Our ref: WA/2015/120746/01-L01
Your ref: 15/01012/OUT
Date: 09 July 2015

**Outline - development of up to 48,308sqm of employment floorspace (class B1C, B2, B8 and ancillary B1A uses), the siting of buildings to the south of the site, servicing and circulation areas, vehicular and pedestrian access from Skimmingdish Lane and landscaping
Land North East Of Skimmingdish Lane, Launton, Oxfordshire**

Environment Agency position

**FRA Map centred on Skimmingdish Lane - Bicester
Created 09/10/2012 - REF: OX_0115_02**

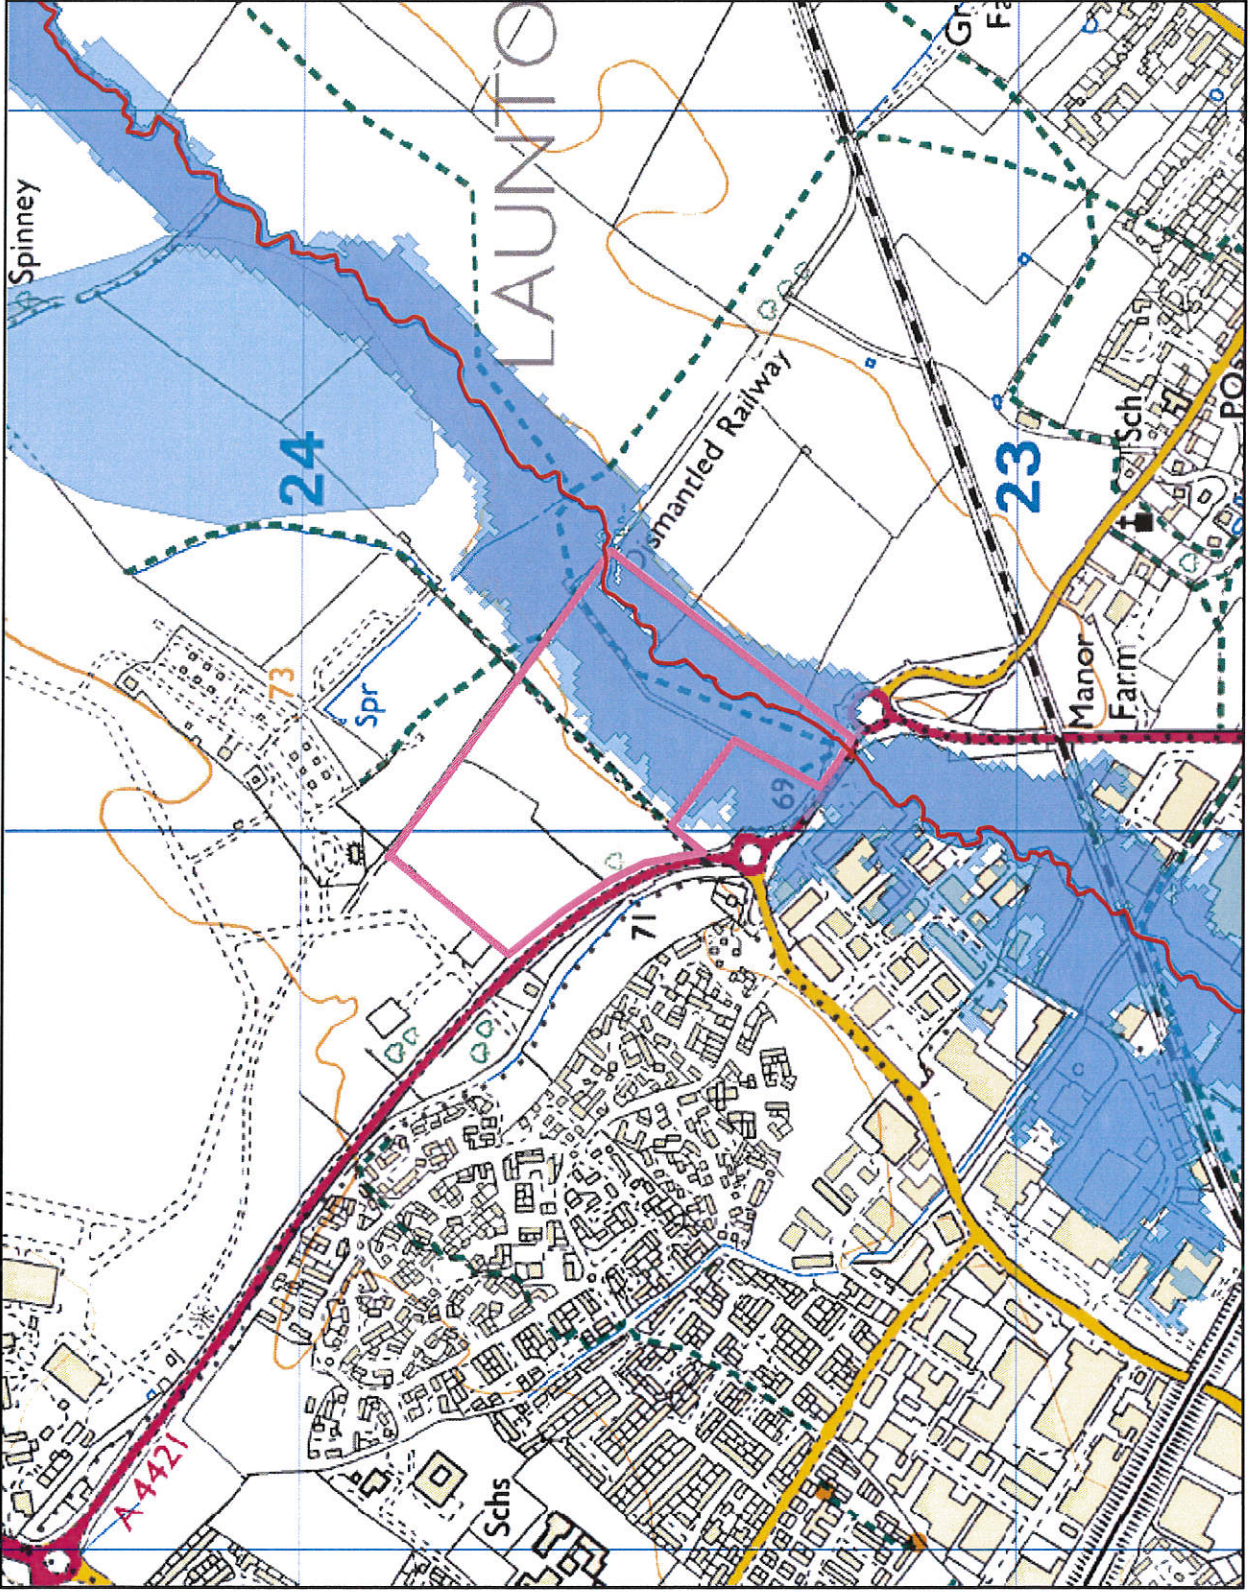
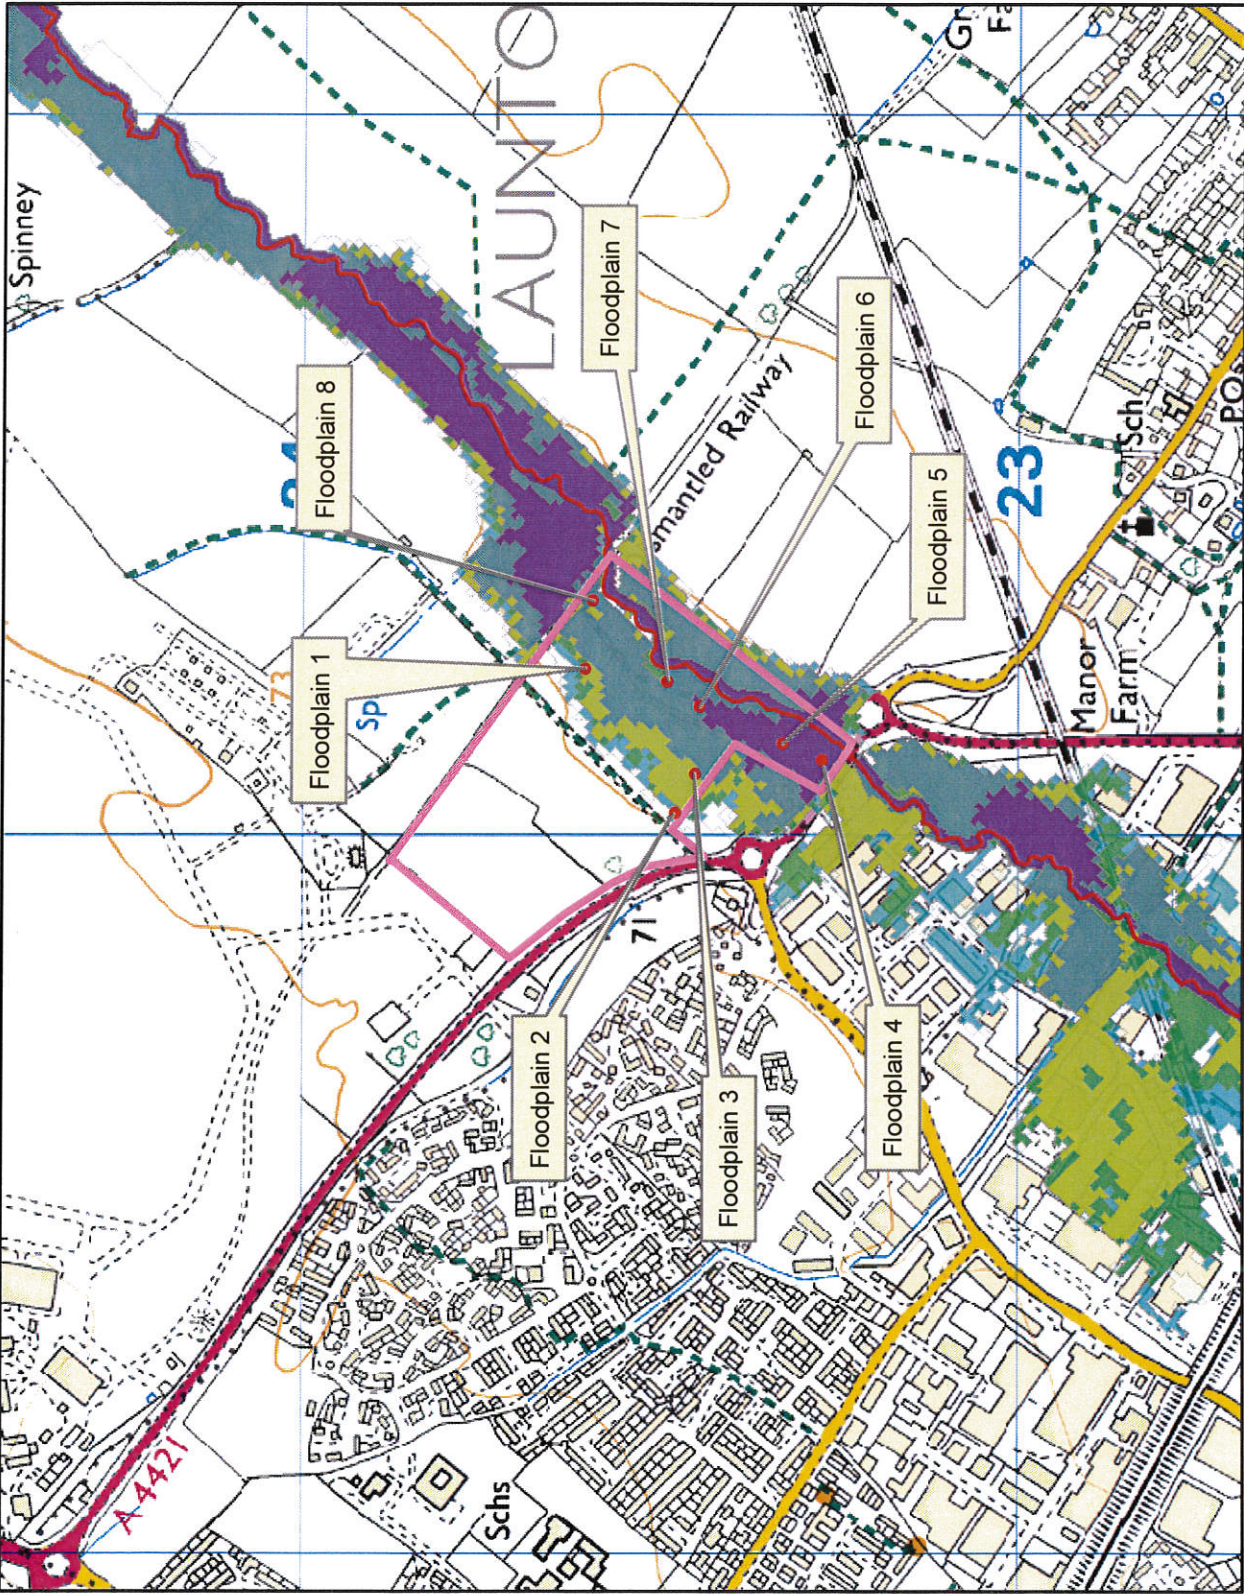
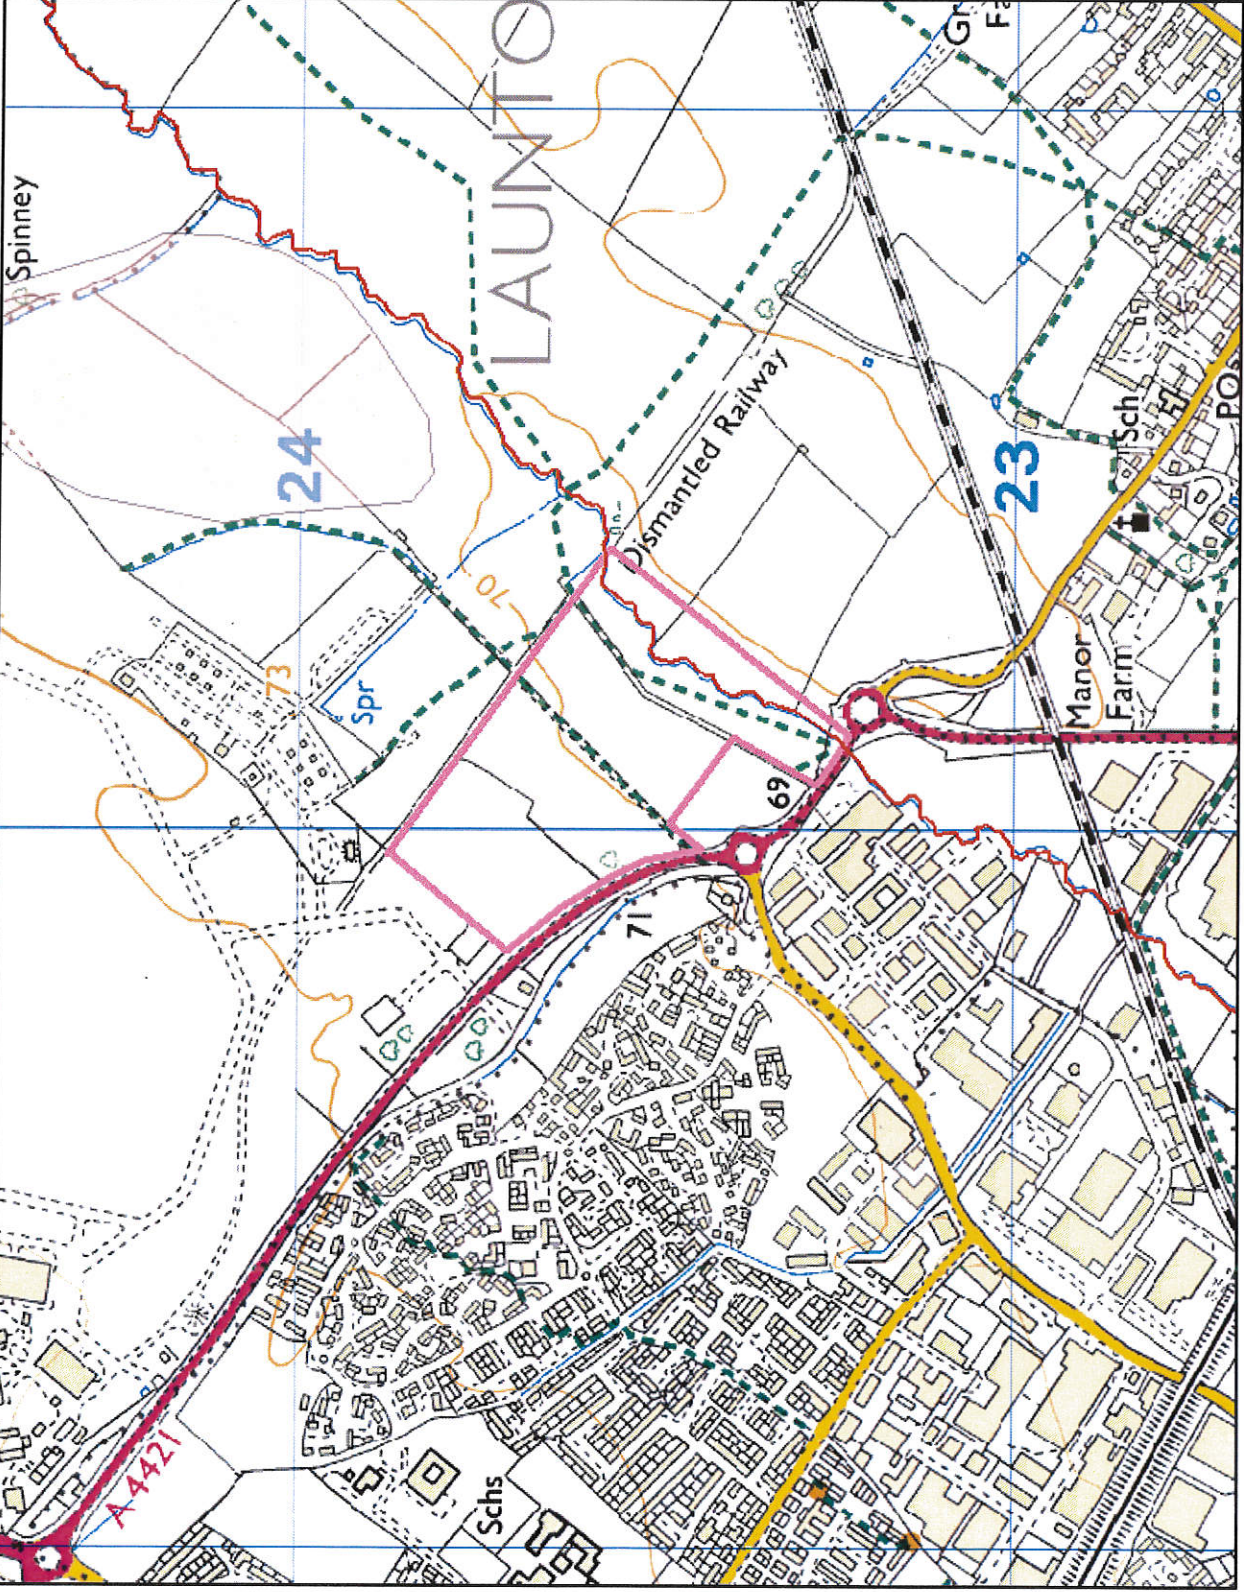
In particular, the submitted FRA fails to demonstrate the proposed development site is in Flood Zone 1 (low risk) as it states. It appears part of the development site including buildings lie within Flood Zone 3. The FRA should be revised to include a detailed topographic survey and assessment of whether the modelled flood level stated in the FRA (69.85m aODN) affects the site. If the site is within Flood Zone 2 or 3 a Sequential Test is required and a more detailed FRA would have to be undertaken (subject to the Sequential Test being passed) to demonstrate what mitigation will be provided to ensure the development is safe without increasing flood risk elsewhere.

As the proposal for this 15Ha site includes a large amount of impermeable hard standing it is important the FRA demonstrates that the development manages both surface water discharge rates and volumes, to ensure flood risk on the Langford Brook is not increased.

You can overcome our objection by submitting an FRA which covers the deficiencies highlighted above and demonstrates that the development will not increase risk elsewhere and where possible reduces flood risk overall. If this cannot be achieved we are likely to maintain our objection to the application. Production of an FRA will not in
